**Re: Formal Objection – Application Ref. 2025/62/92309/E – Proposed development at 39/39A Beckett Road, Dewsbury, WF13 2DD**

I write on behalf of my client, the owner/occupier of the neighbouring property to the above site, to object to the proposed development on the grounds of over-development of the plot and unacceptable harm to neighbouring residential amenity, notably loss of daylight/sunlight and increased overshadowing to my client's home and garden.

Drawing title Proposed Elevation

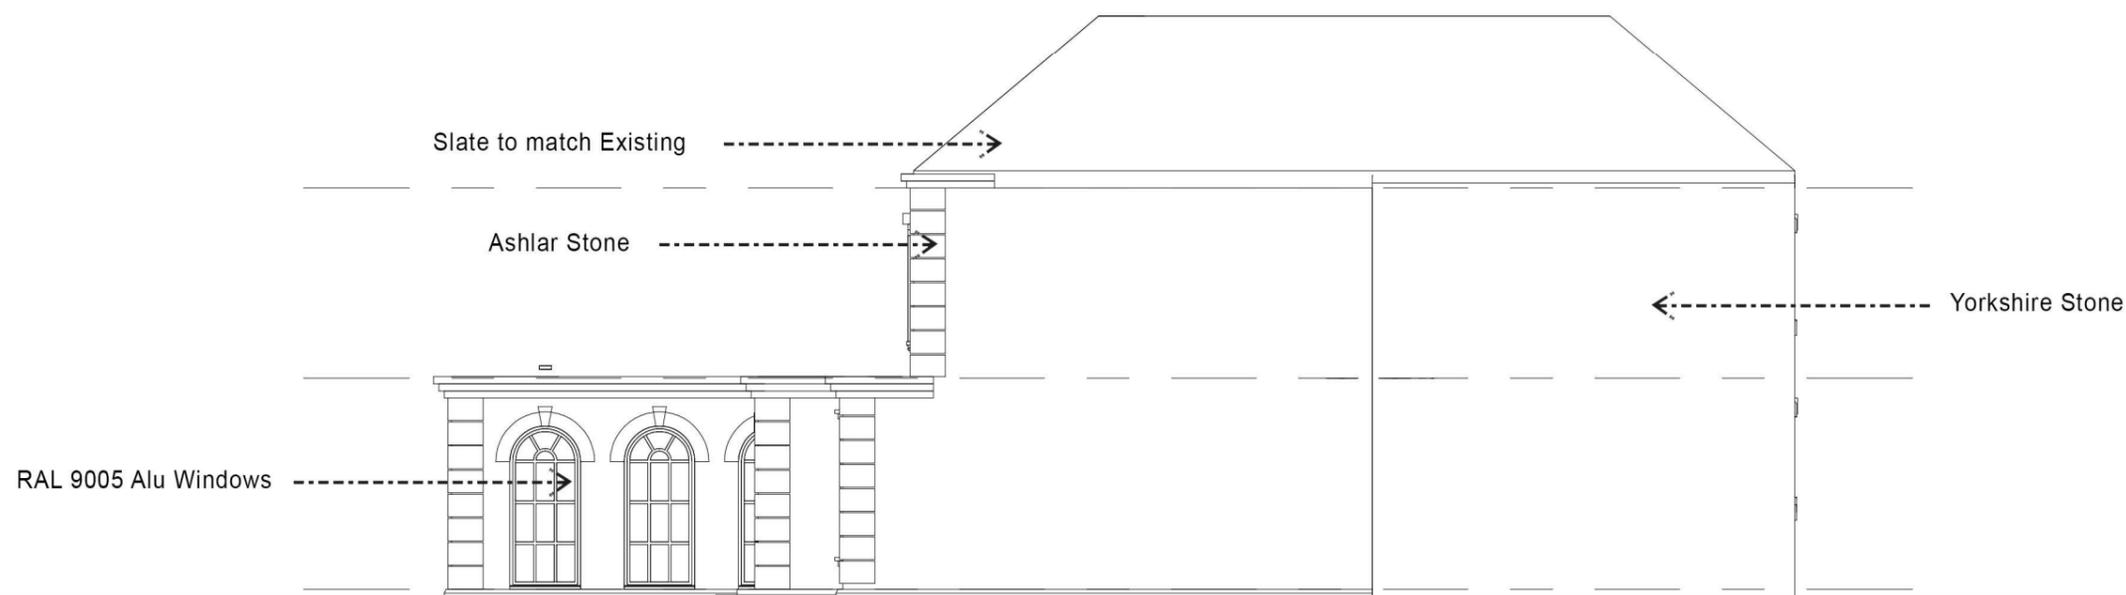
My client's principal windows and garden stand to suffer a material loss of daylight/sunlight and increased overshadowing from the enlarged two-storey envelope close to the boundary, contrary to LP24. The SPD requires minimum separation distances (21m between opposing habitable rooms; 12m to a blank gable) to avoid overbearing and protect amenity. No daylight/sunlight analysis has been provided, so the LPA cannot be satisfied that the scheme preserves neighbour amenity.

Drawing title Site - Location and Block Plan

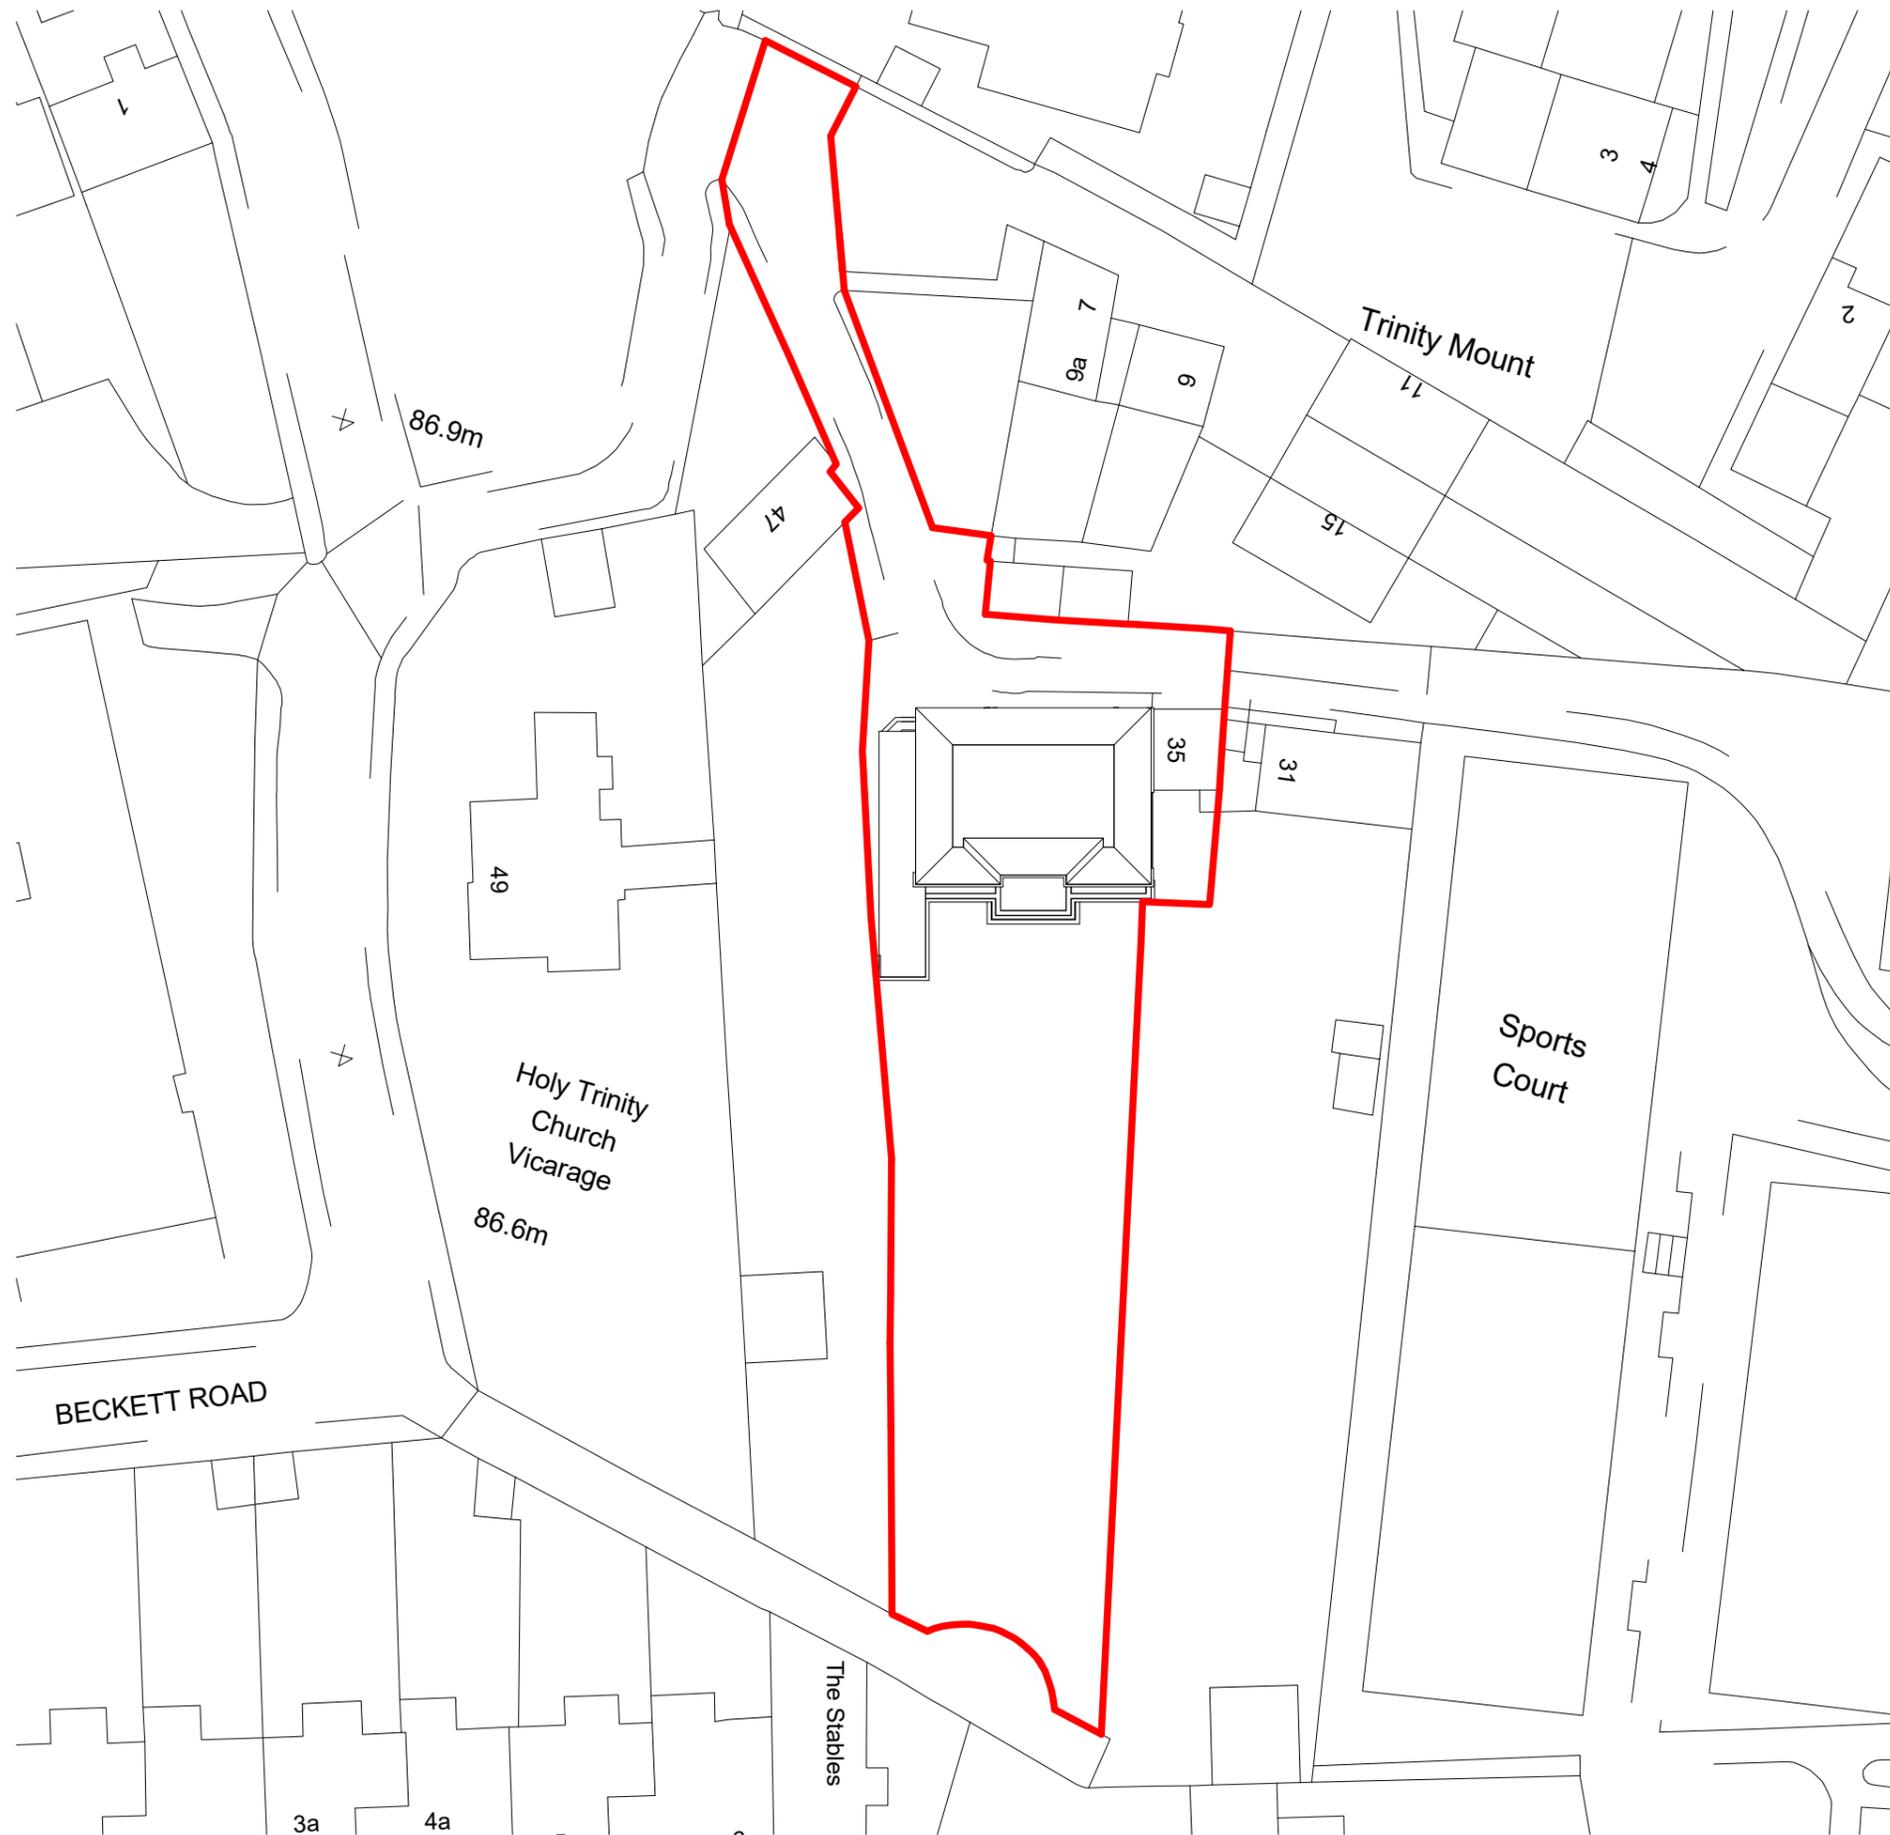
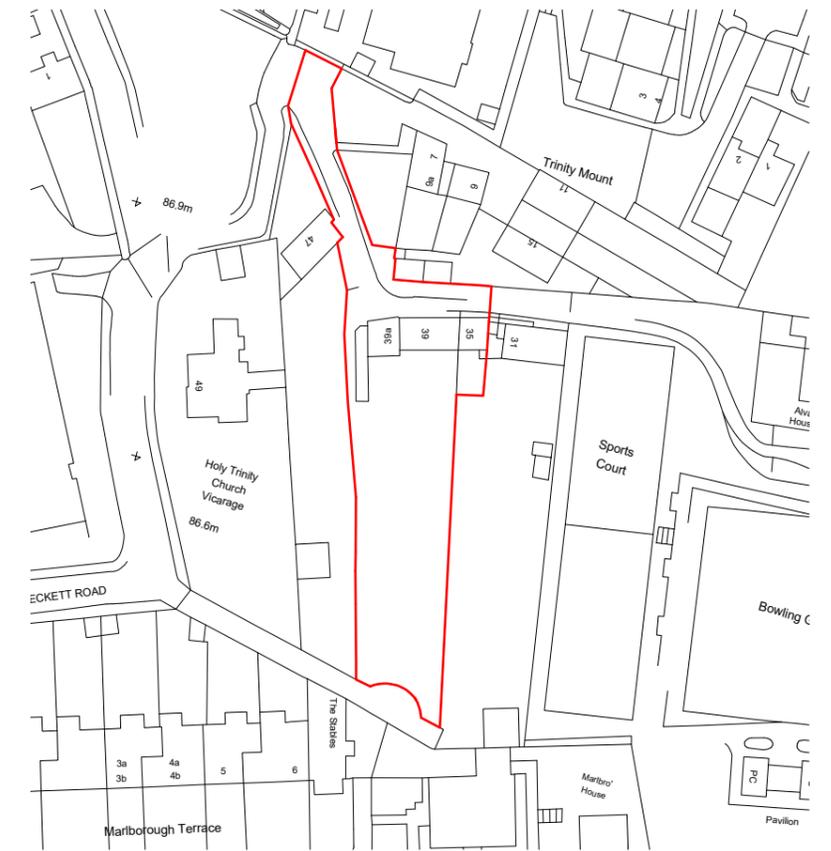
The proposed footprint and two-storey massing read as disproportionate to the plot, with development pushing hard to the side and rear. The SPD expects extensions to be subservient, set back at least 500mm from the front wall, maintain a minimum 1m gap to side boundaries, and retain at least half of the garden as usable private space. On the evidence submitted, the scheme erodes side spacing and consumes a substantial share of the plot, creating the risk of a "terracing" effect. This conflicts with Policy LP24 and the SPD's design principles.
